Application for removal or variation of a condition following grant of planning permission.
 Town and Country Planning Act 1990.
 Planning (Listed Buildings and Conservation Areas) Act 1990

Erection of single storey side and rear extensions, front porch, 2no. rear dormer windows, one with Juliette balcony/railings, 5no. roof lights, alterations to windows/doors, front first floor balcony with railings, flue to side elevation, double garage with linked roof, solar panels, front garden wall/gate, 1.8m fence/gate, shed, garden room, raised rear platform with railings, 6m flagpole, bin storage, steps, patio/hardstanding, extension to vehicle access and driveway (existing porch, single storey rear extension, 2 no. dormer windows and 2 no. outbuildings to be demolished)

Beachcombers, Cliffe Road, Kingsdown, CT14 8AJ
 Variations to drawings relating to planning
 permission 22/00962
**Drawing J1 - Front Elevation and Front part of
 North Side Elevation**
 Scale 1:100 at A4
 24 February 2024

**Drawing J1 - Front Elevation and Front part of  
 North Side Elevation**

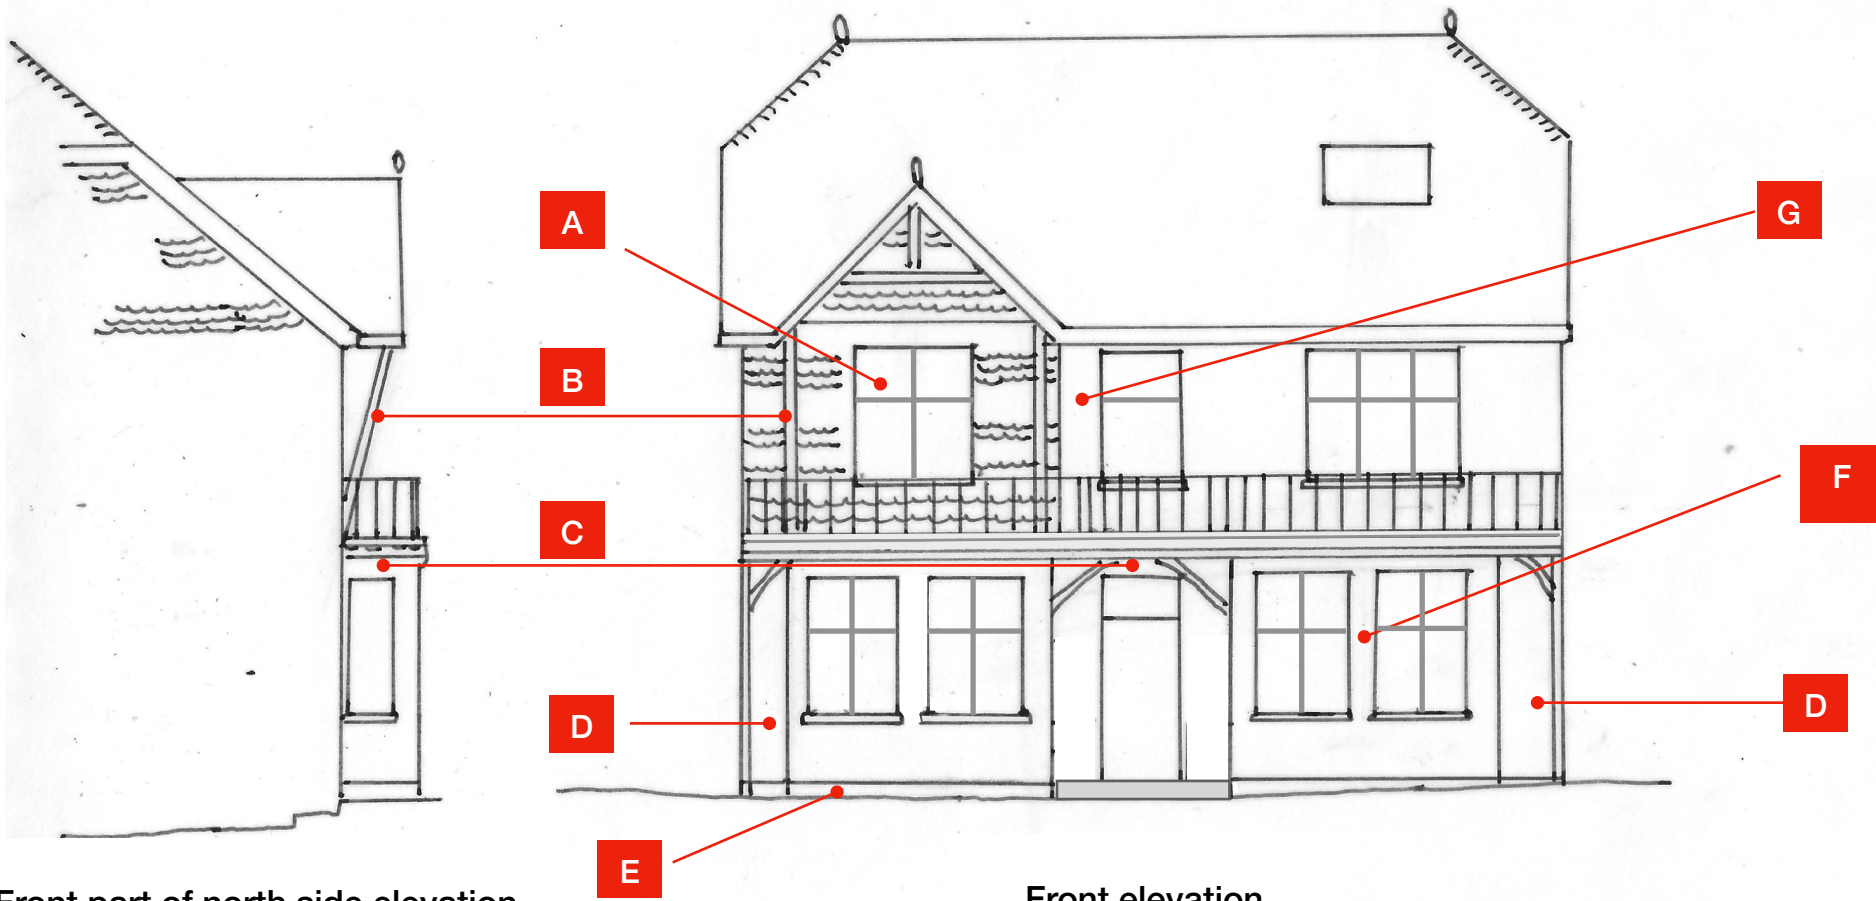
A	Slightly smaller window
B	Gable support changed
C	Porch becomes smaller, in line with bays
D	Brickwork to side of bays retained (no longer being tile hung)
E	Rendered and painted decorative skirt across front
F	Brick pillar in middle of both front bays for aesthetics and ease of construction and glazing
G	Reduced area of tile hanging, existing render retained

Beachcombers, Cliffe Road, Kingsdown, CT14 8AJ
Variations to drawings relating to planning permission 22/00962
Drawing J2 - South Side Elevation
 Scale 1:100 at A4
 24 February 2024

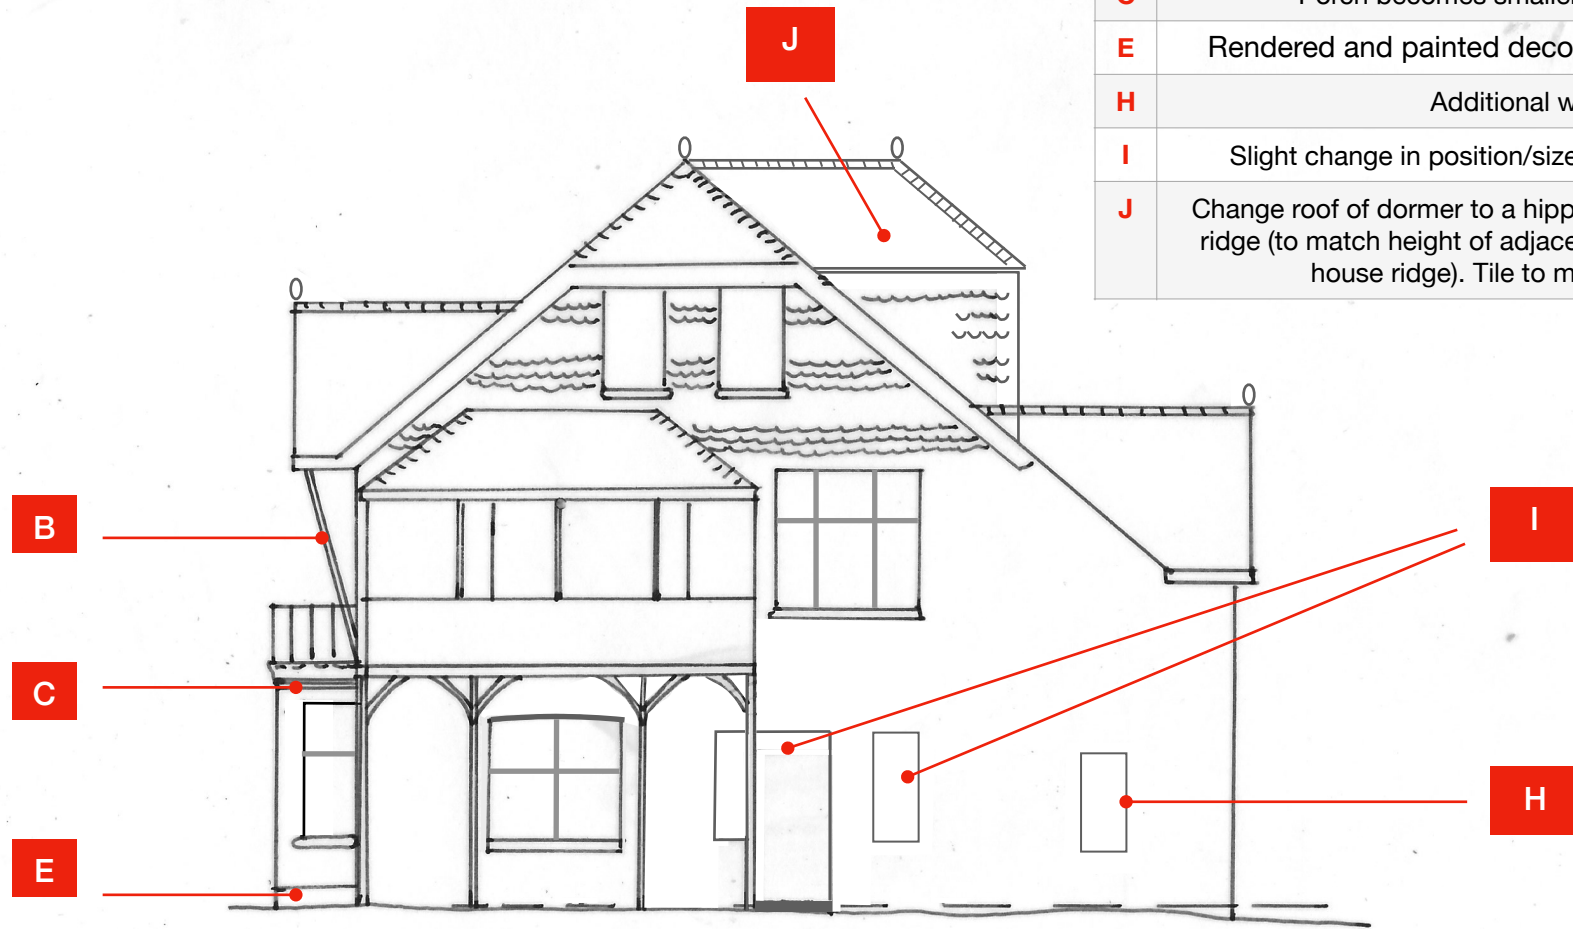
B	Gable support changed
C	Porch becomes smaller, in line with bays
E	Rendered and painted decorative skirt across front
H	Additional window
I	Slight change in position/size of doors and windows
J	Change roof of dormer to a hipped roof with slightly higher ridge (to match height of adjacent dormer and meet main house ridge). Tile to match house roof.
